Application for Removal or Variation of a Condition following Grant of Planning Permission or Listed Building Consent

Demolition and replacement of the existing detached dwelling and garage, with a new detached two storey dwelling (including habitable roof space with 2 front and 2 rear dormers, 6 roof lights and a basement) and associated landscaping and ancillary works.

47172/APP/2022/3635

Approved Drawings: 1393/P/1A, 2A and 3A

rev. date: description:  
scale: 1:100 A1 date: 09/11/2022  
drawing no: 1393 / P / 2B drawn: TF  
drawing:  
project: 29 NICHOLAS WAY  
NORTHWOOD, HA6 2TR  
client: MR AND MRS PATEL

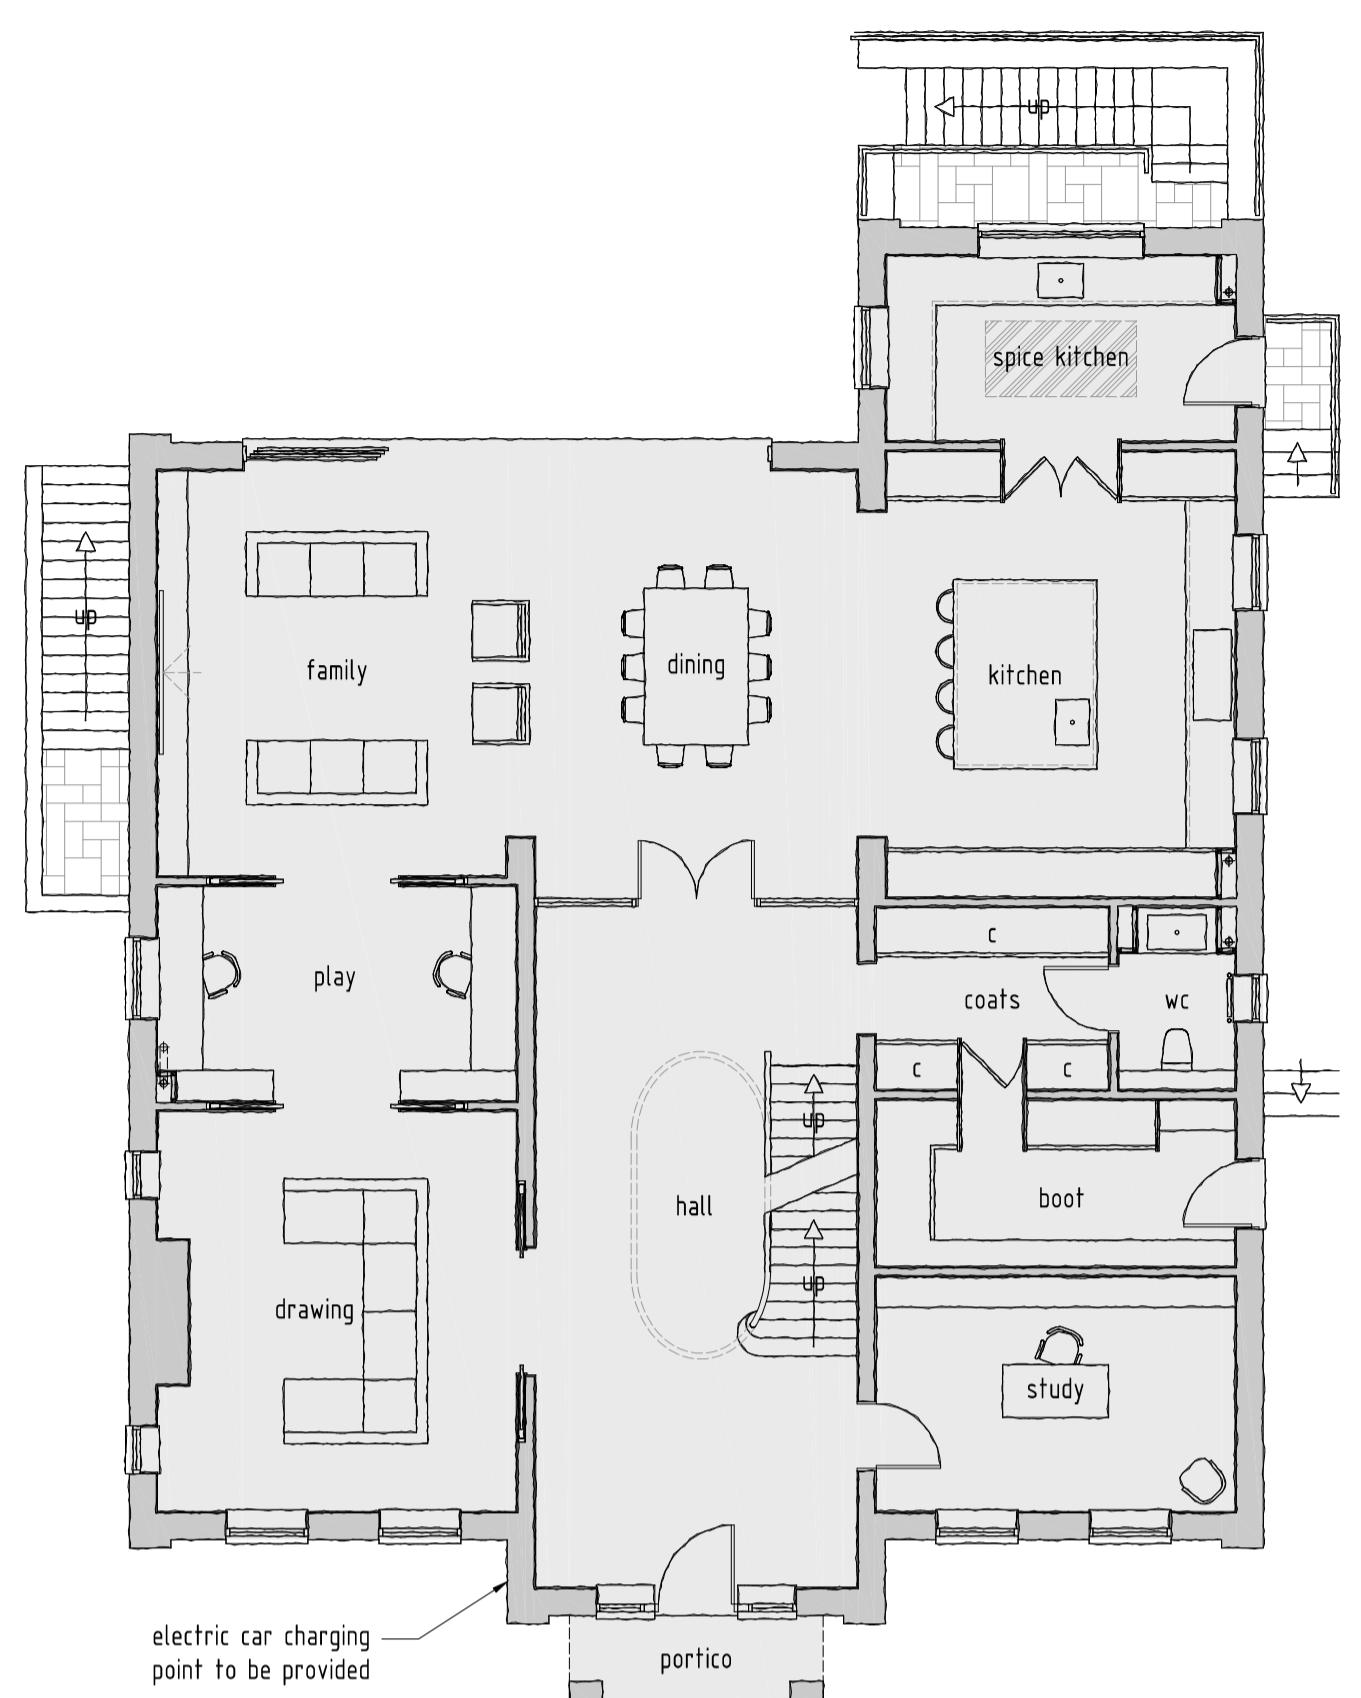
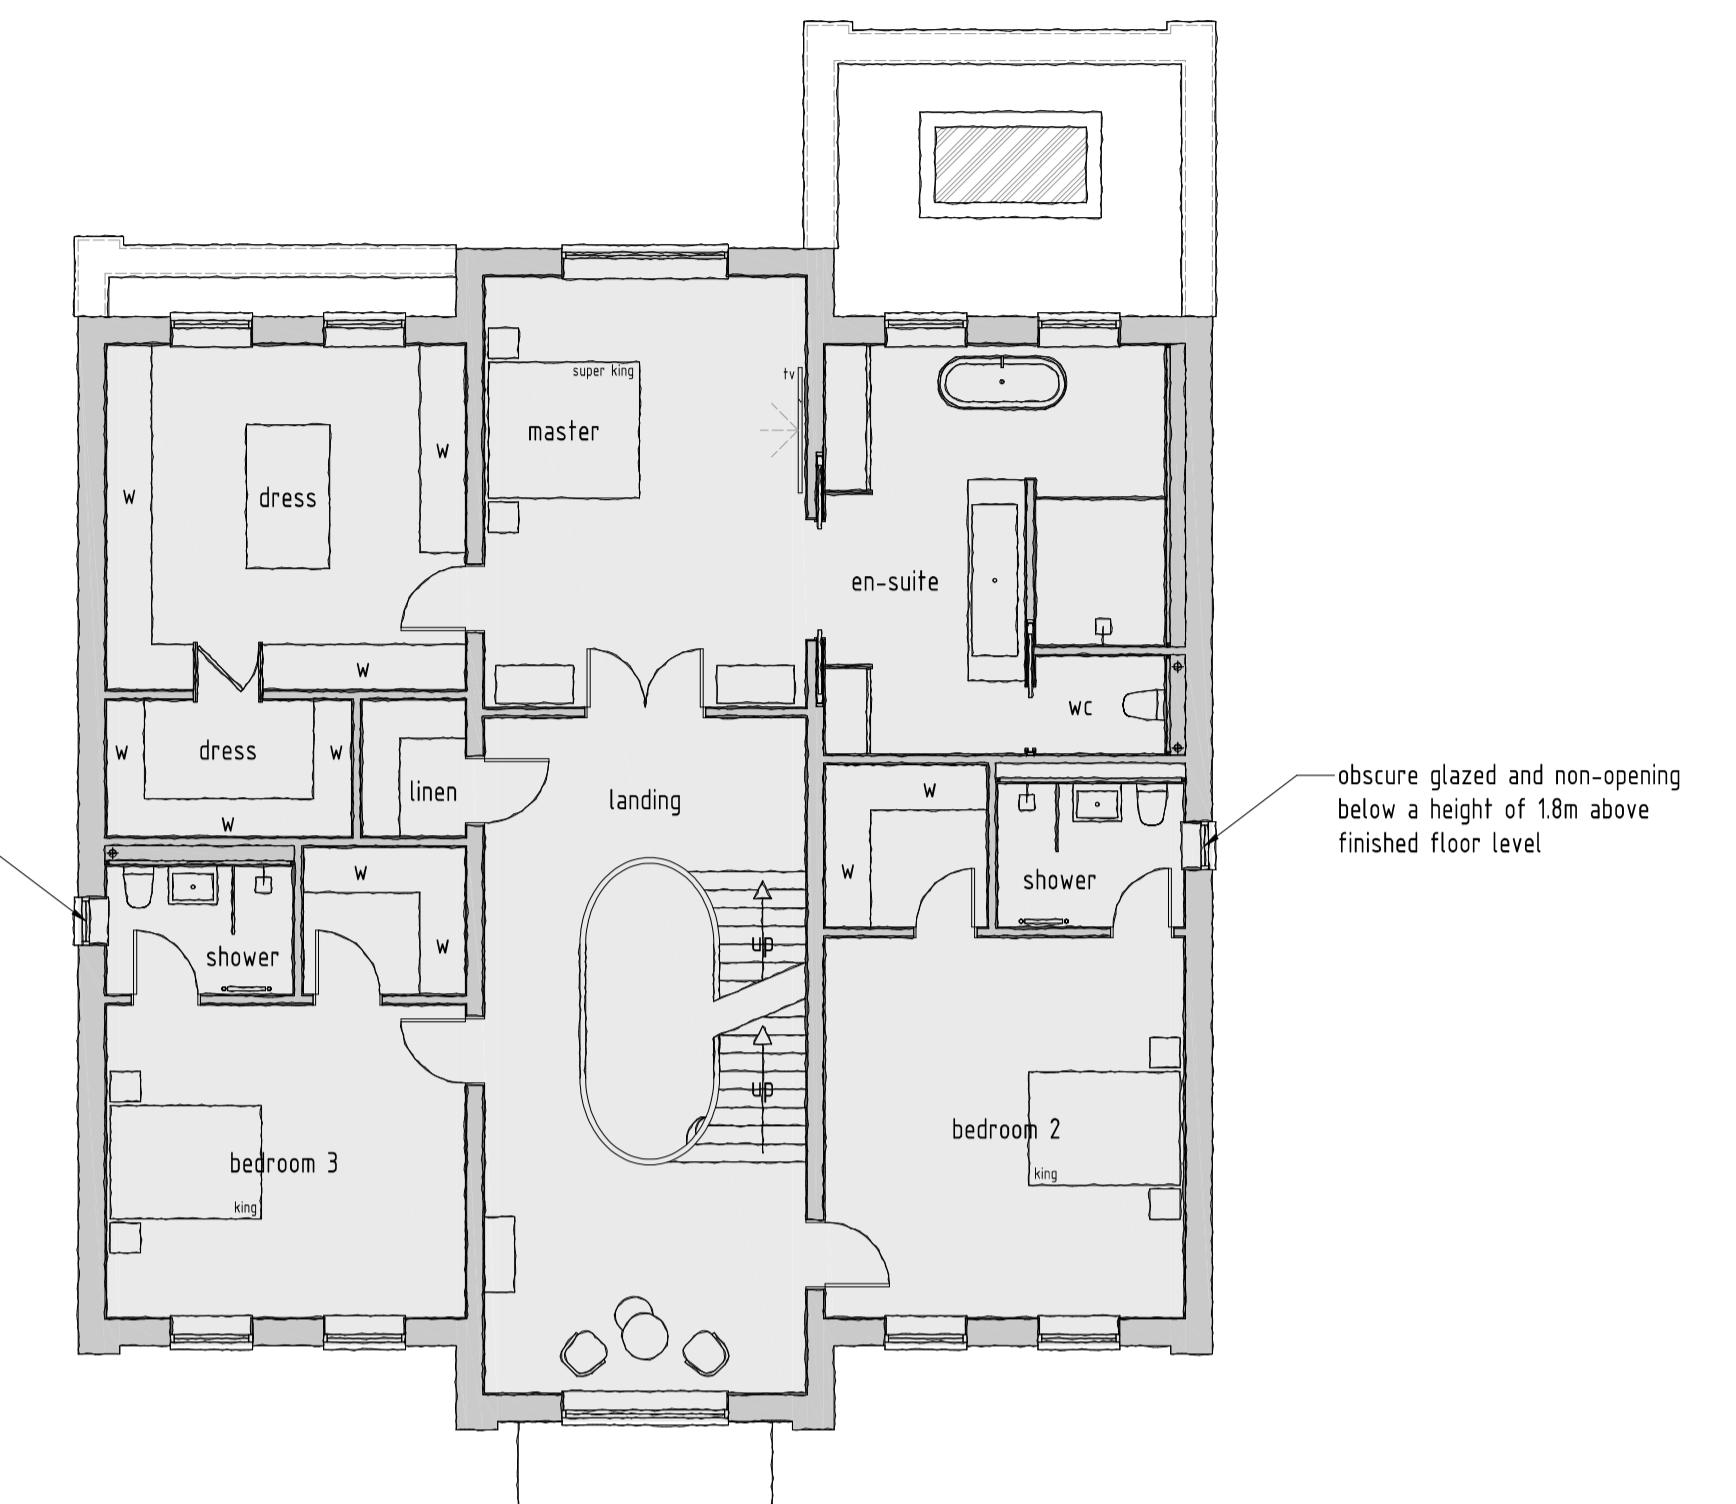
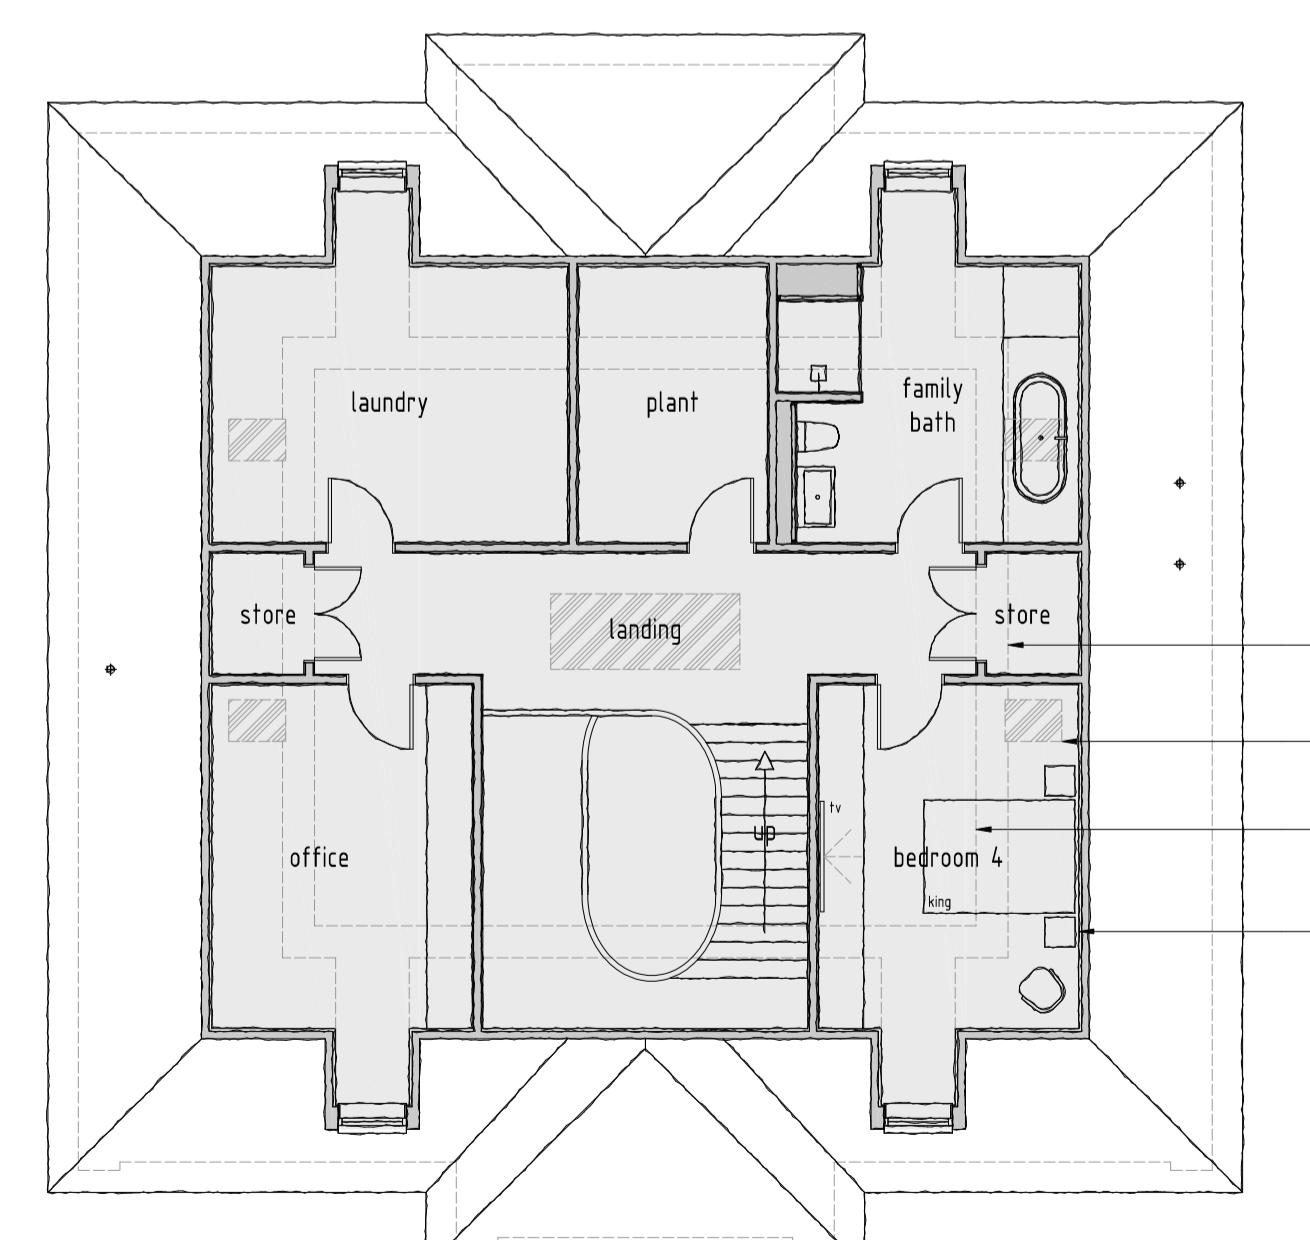
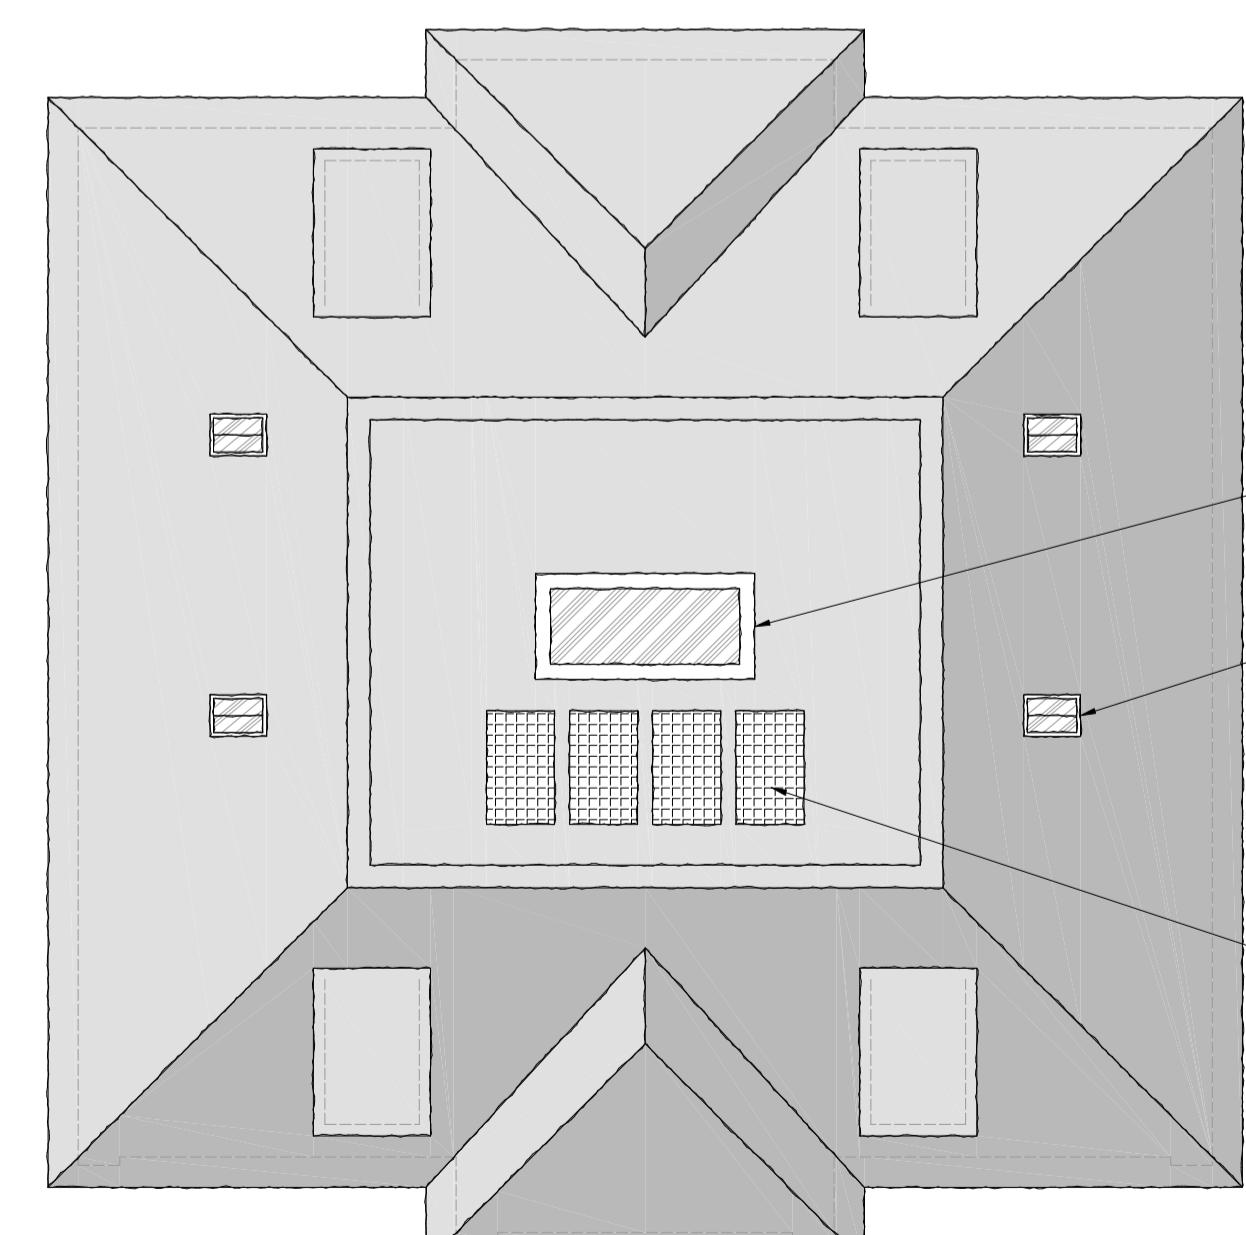
8. General changes to internal layout.

Drawing nos, 1393/P/1B, 2B and 3B.
